**APPLICATION BY MONA OFFSHORE WIND LIMITED FOR AN
ORDER GRANTING DEVELOPMENT CONSENT FOR THE MONA
OFFSHORE WIND PROJECT**

**PLANNING INSPECTORATE REFERENCE NUMBER
EN010137**

SUPPLEMENTARY WRITTEN REBUTTAL SUBMISSION

PROMOTER'S DOC NO. MOCNS-J3303-DMC-10453

UPDATED INDICATIVE MAIN TEMPORARY CONSTRUCTION COMPOUND LAYOUT NOT TO SCALE

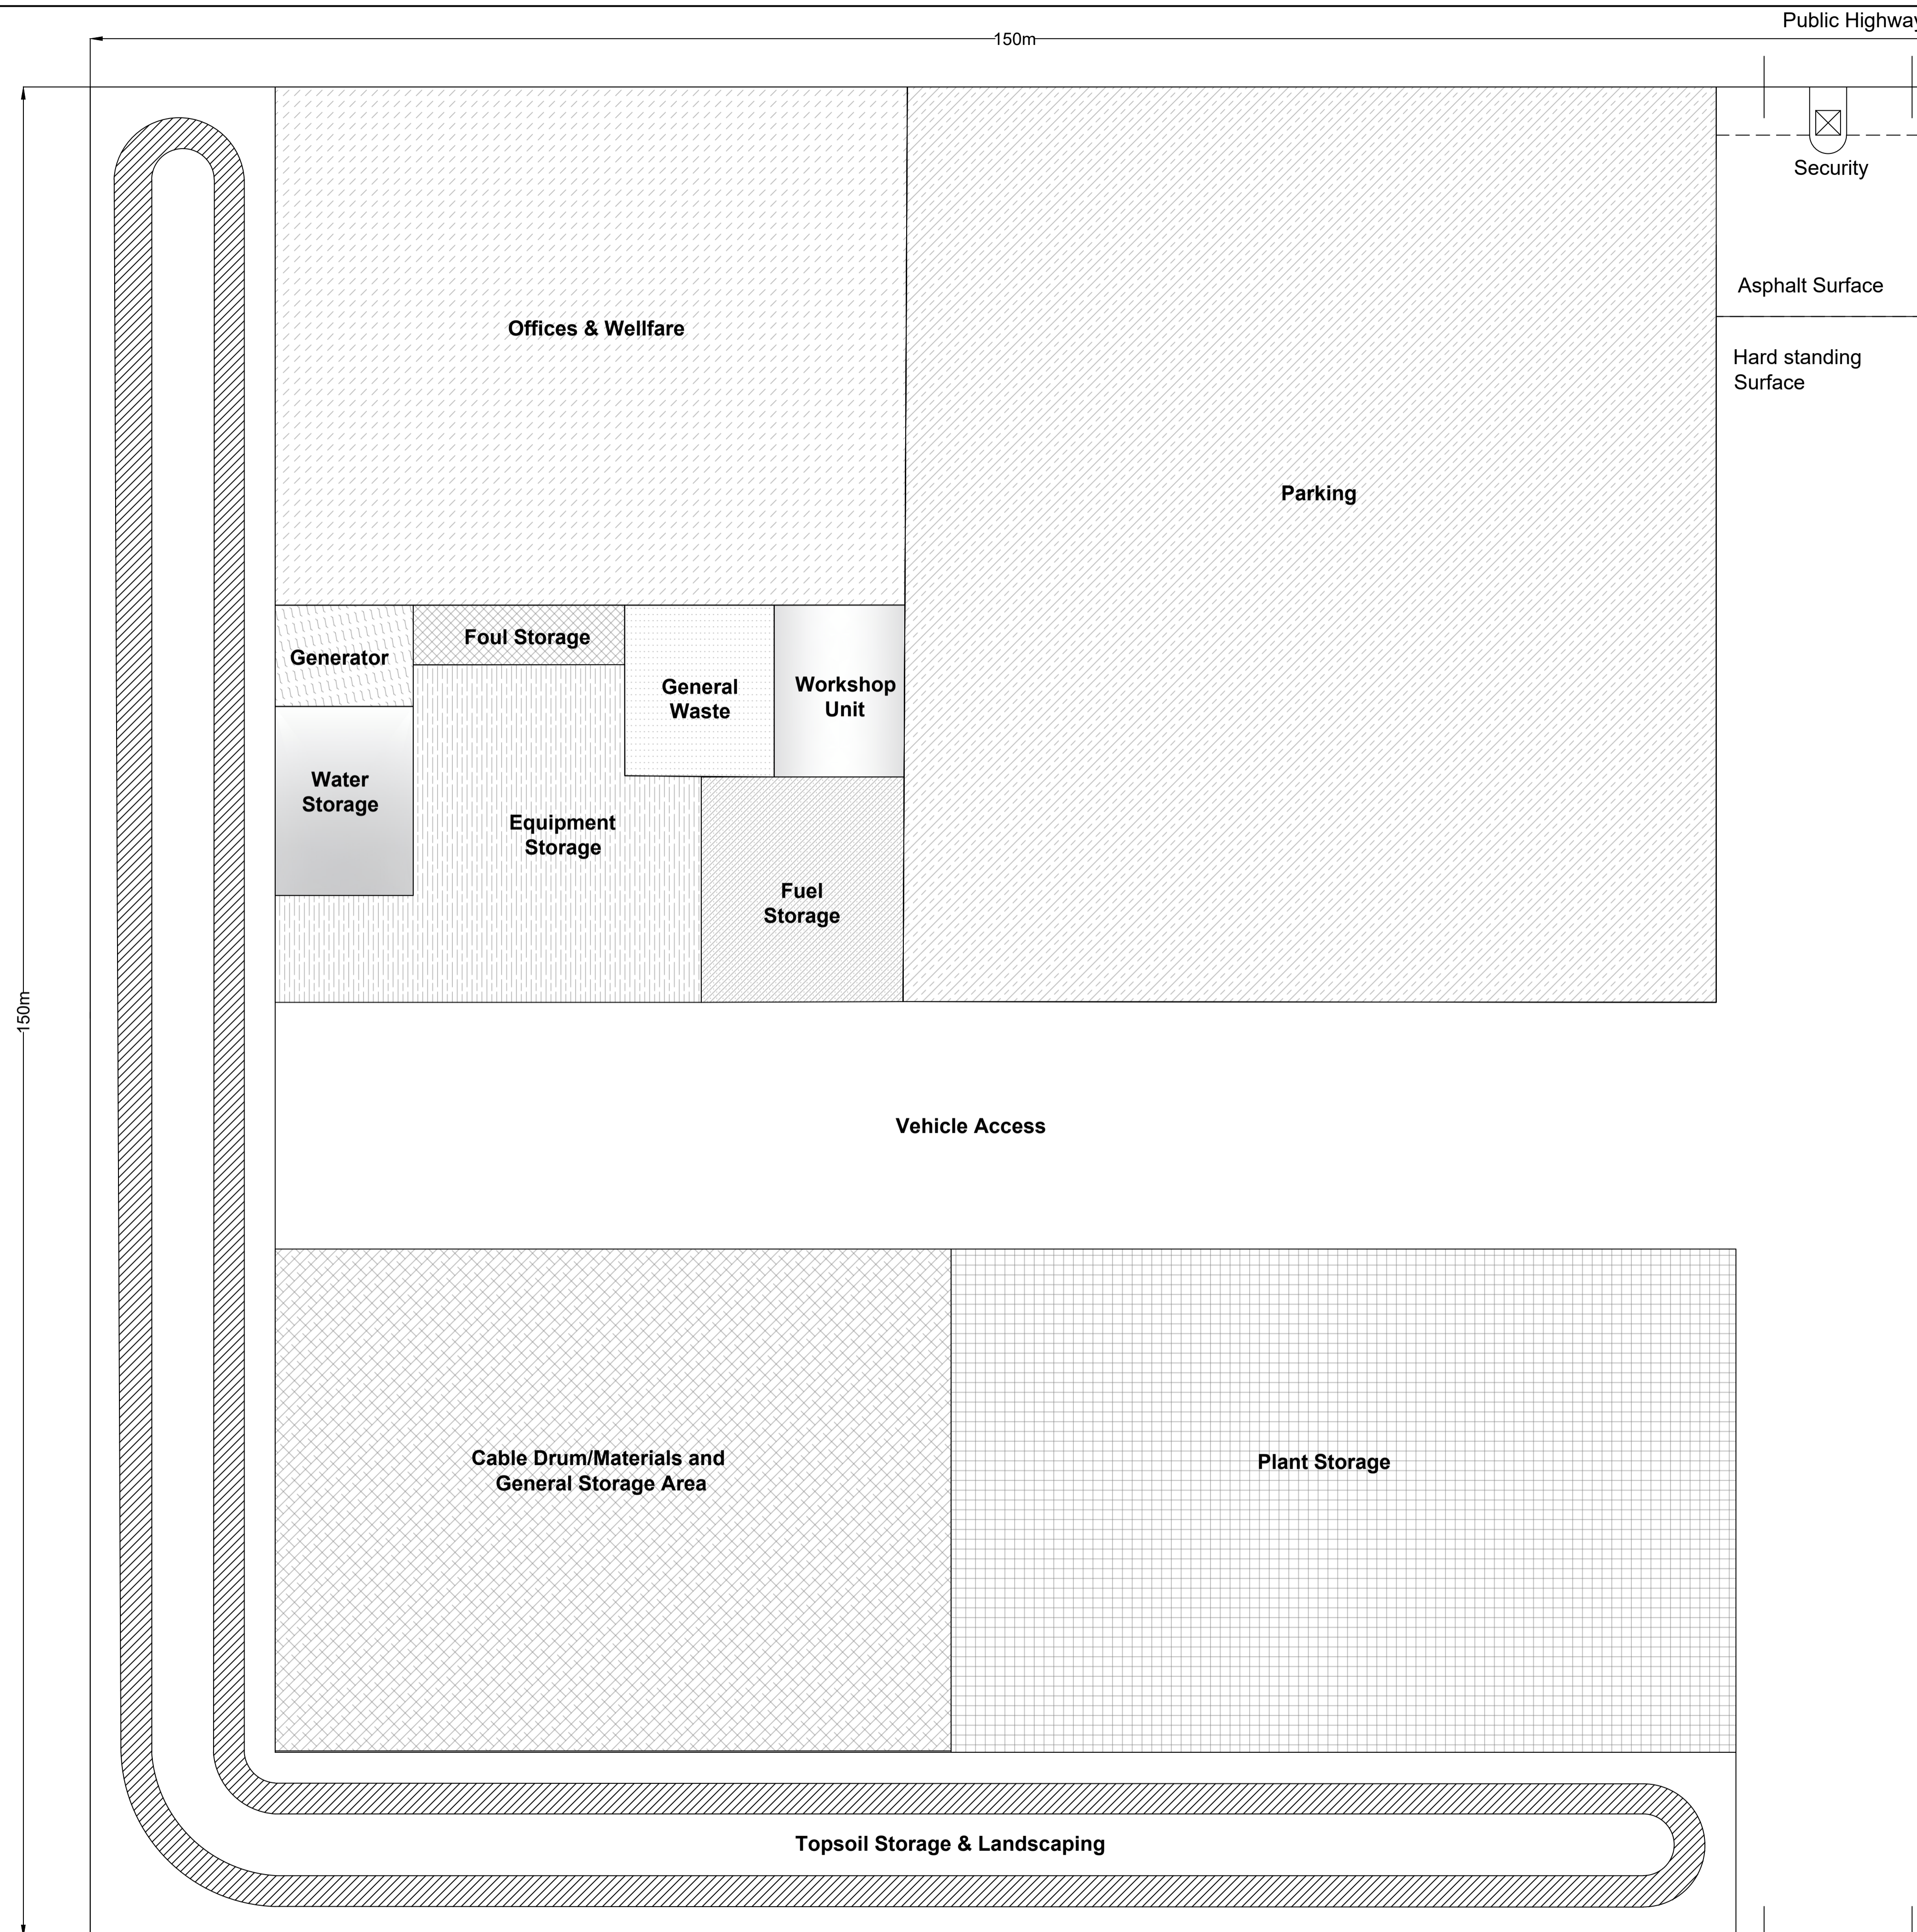
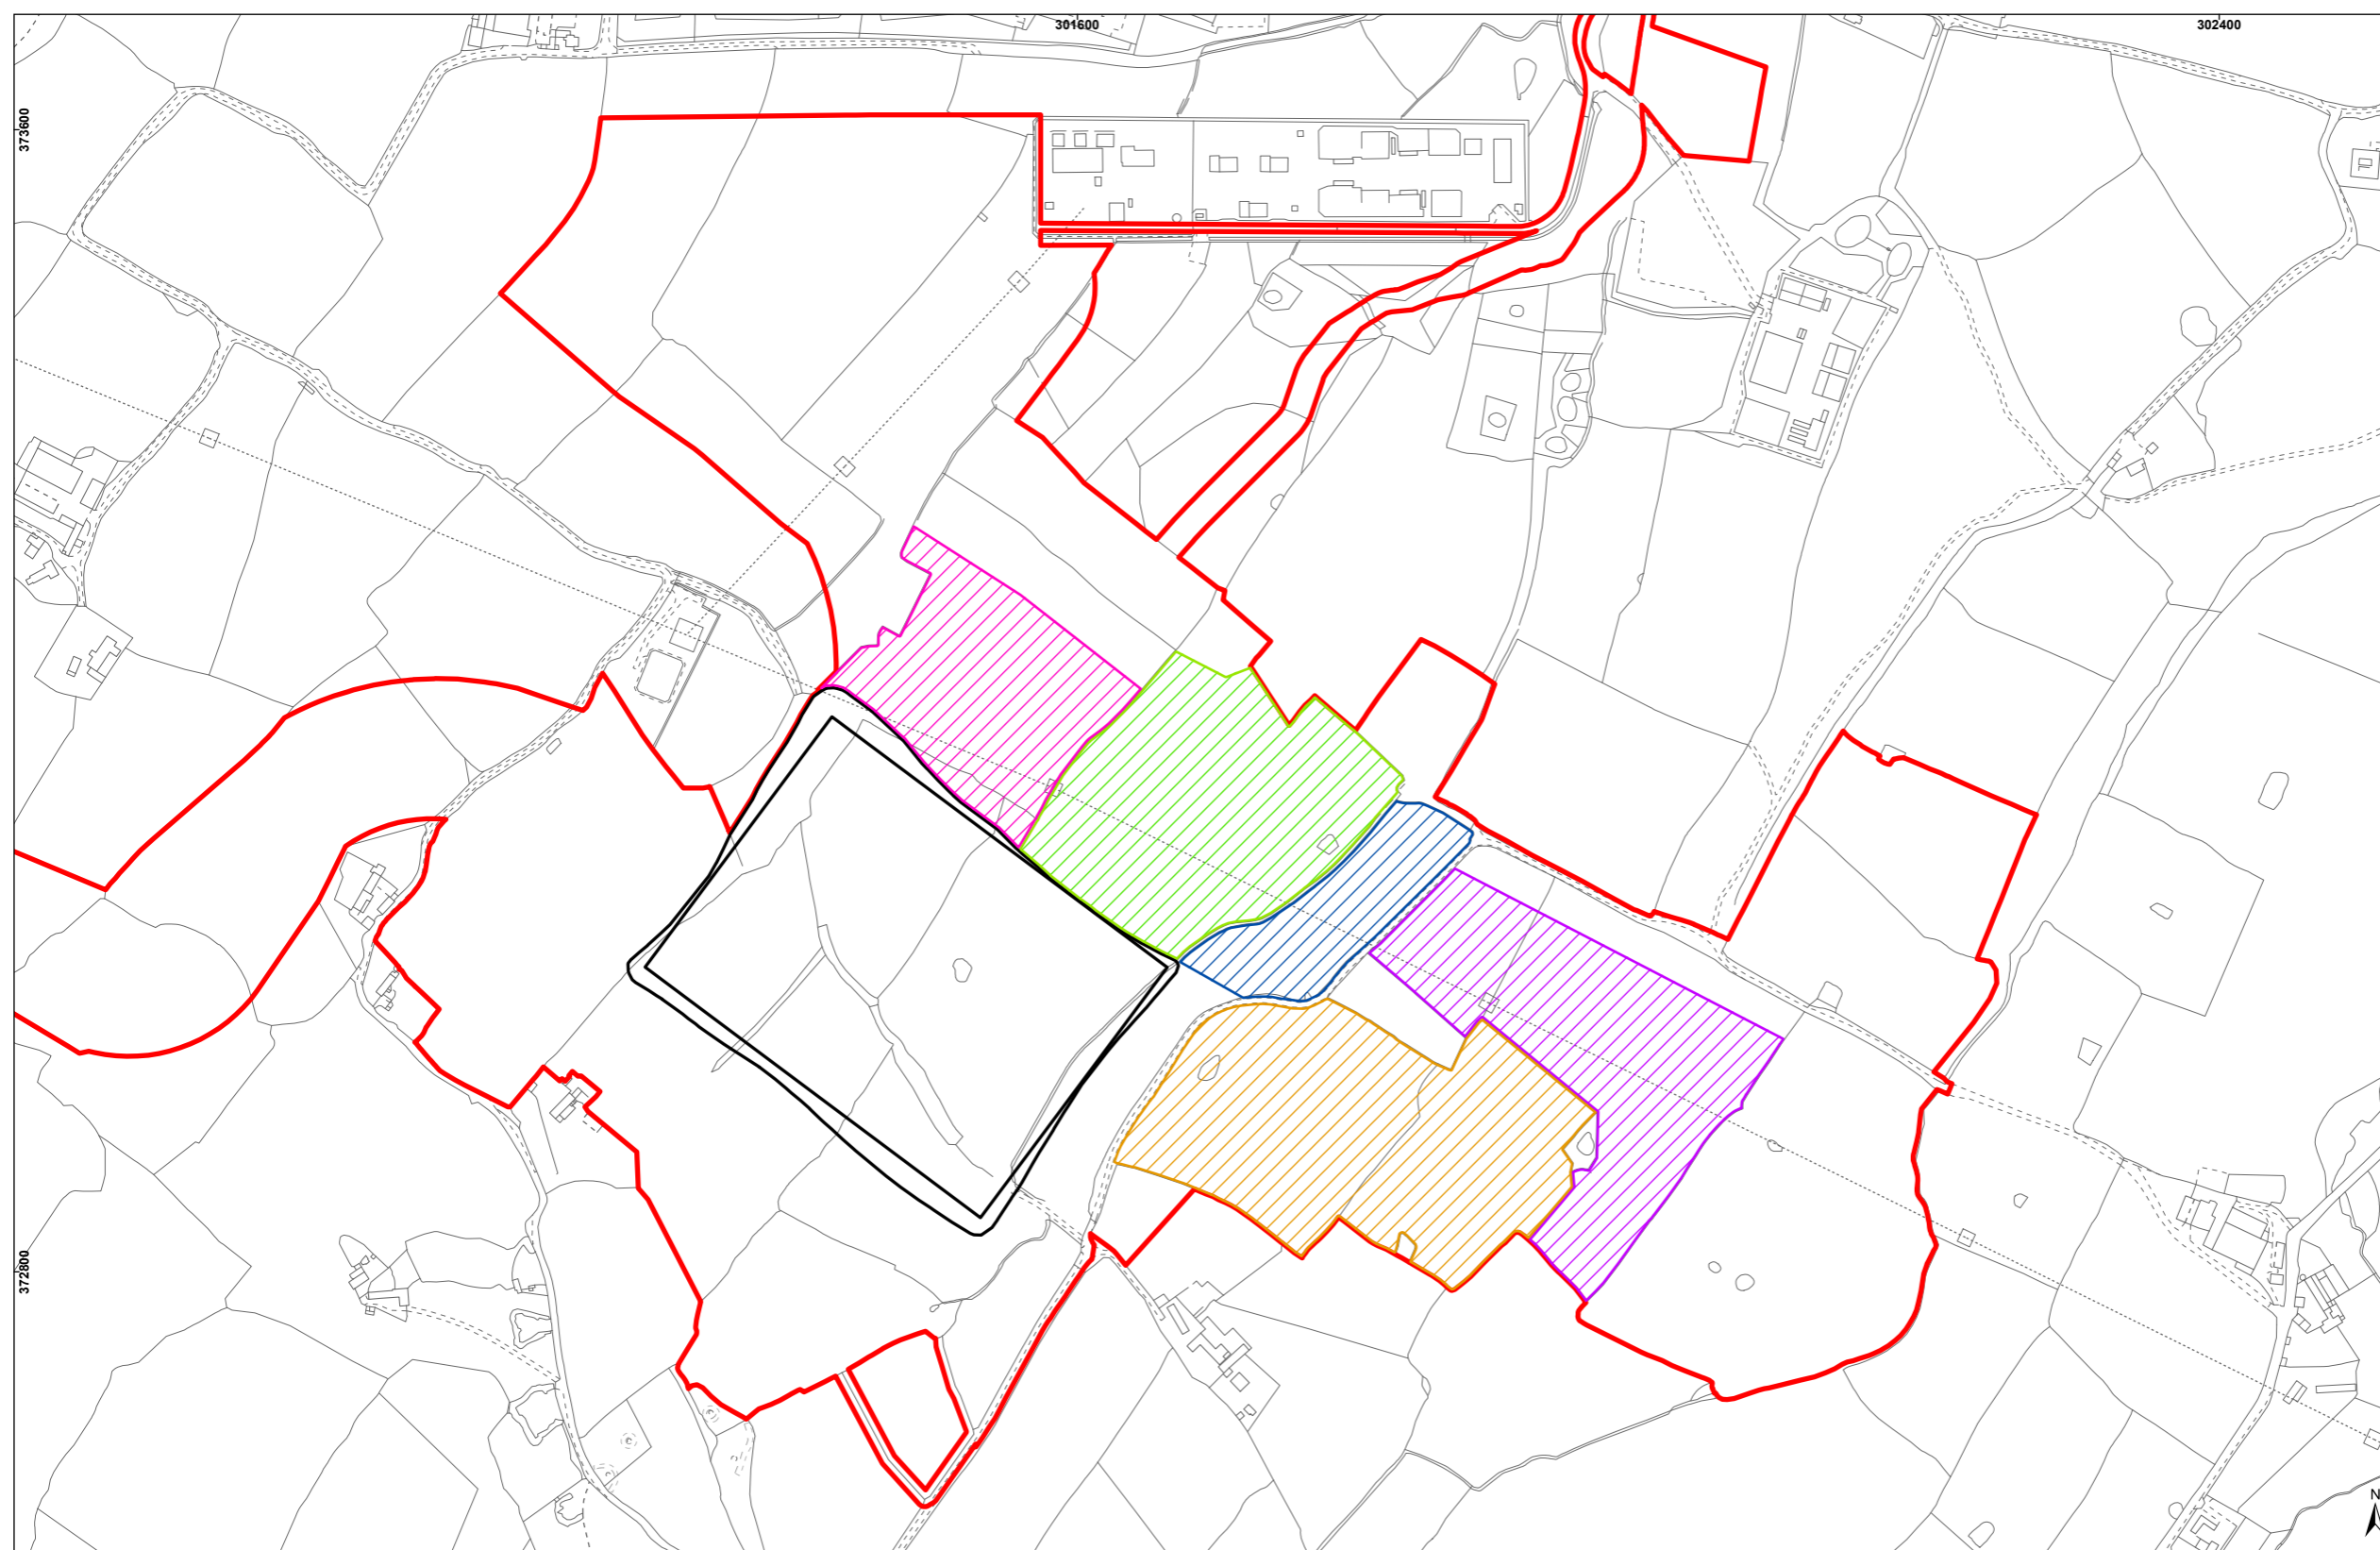
20 An extract from a Promoter provided plan showing the extent of the compound that is proposed. The compound is not a perfect square however, if it is scaled then the Panel will note that it does indeed approximate measure some 188m by 192m. This in turn gives an area of circa a little over 36,000m².
